Recommendation Report for Planning Permission for Works or Extension to a Dwelling

REF NO: LU/27/22/HH

LOCATION: 103 Griffin Crescent
Littlehampton
BN17 7LH

PROPOSAL: Erection of two storey side extension following the demolition of single storey detached garage.

PROPOSED FIRST FLOOR PLAN

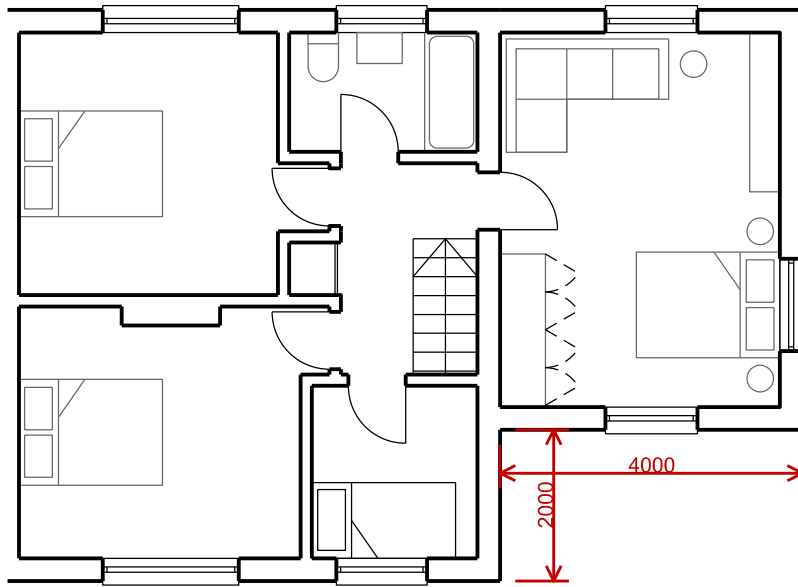
Further to confirmation from the Agent, the west facing first floor window is confirmed to be obscure glazed, this will be conditioned for retention. The proposal is not considered to result in a loss of privacy to local occupiers in that the views provided by the new openings are no different to those existing from the host dwelling.

- 4 The first floor west facing window hereby approved shall be fully obscured and non-opening below 1.7m from finished floor level prior to the first use of the rooms. The windows shall be retained as obscure glazed/non-openable, as described, in perpetuity.

PROPOSED SIDE ELEVATION

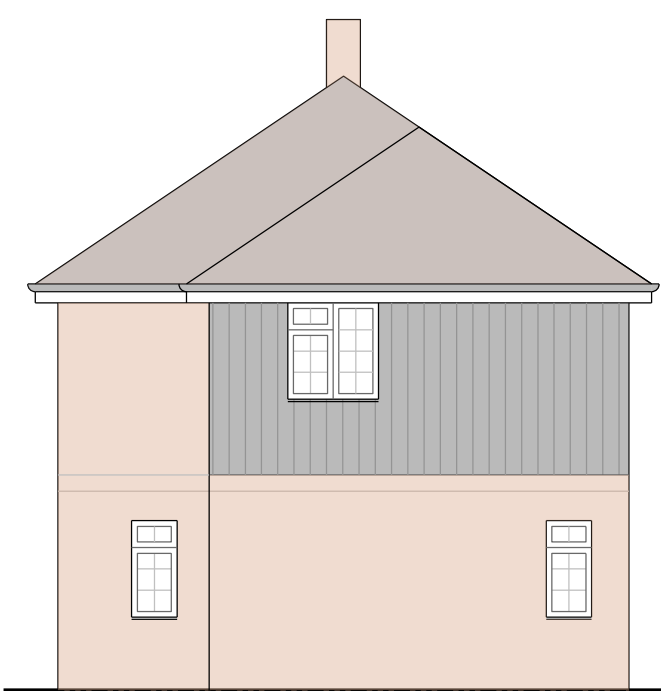
- Objection side facing window overlooking property, would be happy if it was obscure glazed.
